Recommendation Report for Lawful Development Certificate for a Proposed Use or Development

REF NO: EP/142/18/CLP

LOCATION: 3 Selborne Way
East Preston

PROPOSAL: Lawful development certificate for a proposed garden room.

Elevations and Roof plan

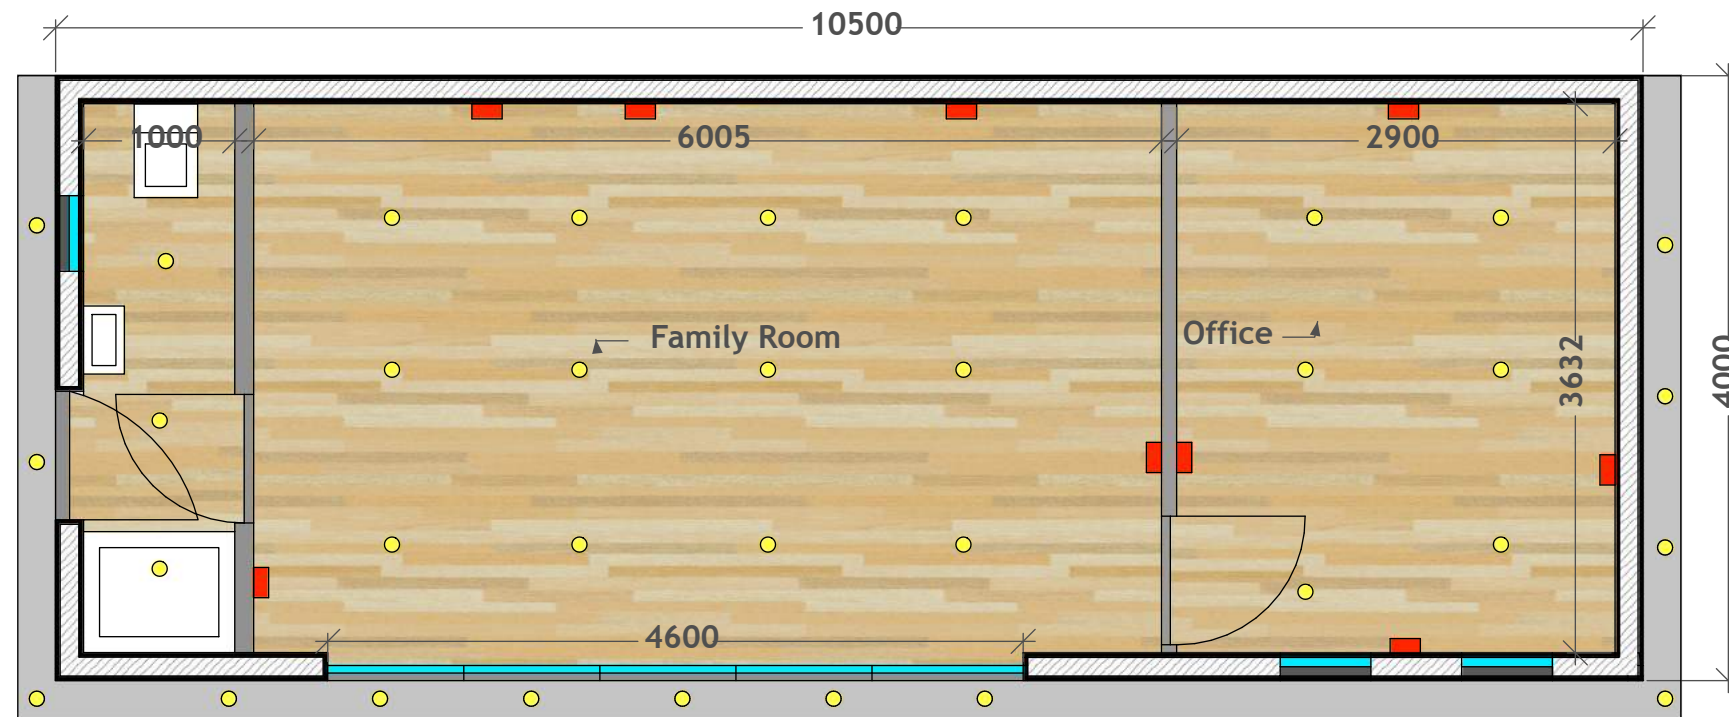
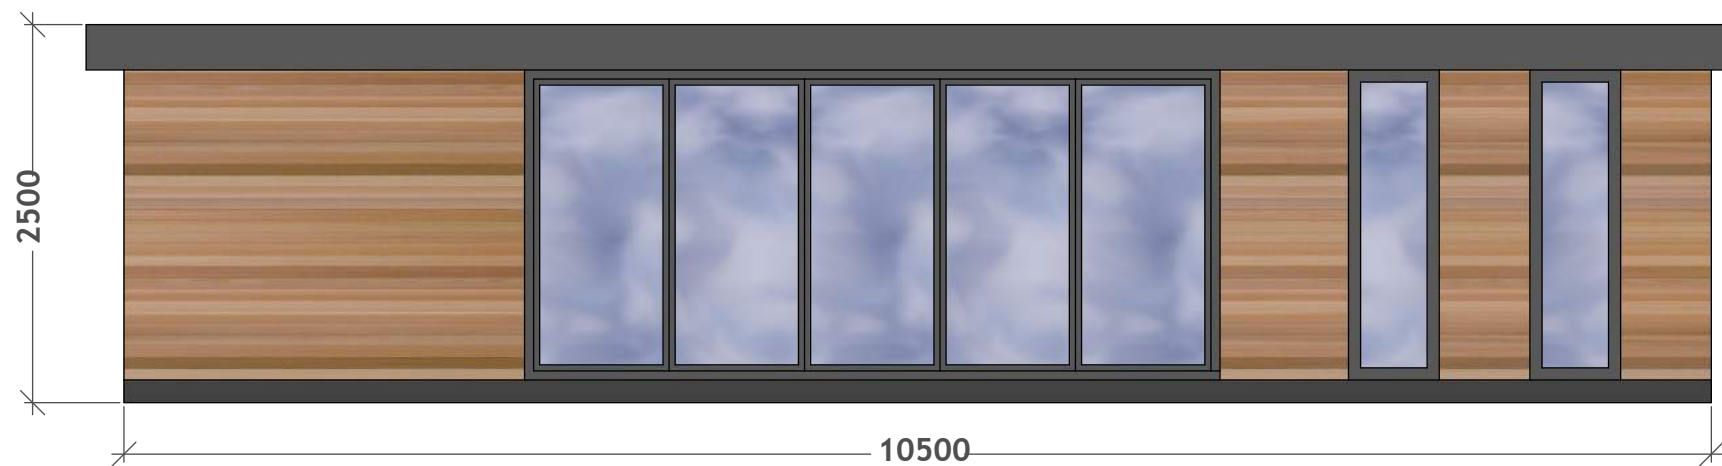
The proposed garden room will be situated 0.5m from the Northern boundary of the site and will be located behind the primary elevation of the dwellinghouse. The outbuilding will have a maximum height of 2.5m and will measure 10.5m in length and 4m in width.

The proposed garden room complies with the limitations of E.1 (a), (b), (c), (d), (e)(ii), (f), (g), (h), (i) and (j); E.2 and E.3 are not considered relevant to this proposal; and the outbuilding is also deemed to be in accordance with the limitations of E.4. Therefore, the proposed garden room is considered to benefit from 'permitted development' rights under Schedule 2, Part 1, Class E of the Town and Country Planning (General Permitted Development) Order 2015 (as amended) and as such does not require the submission of an application for planning permission.
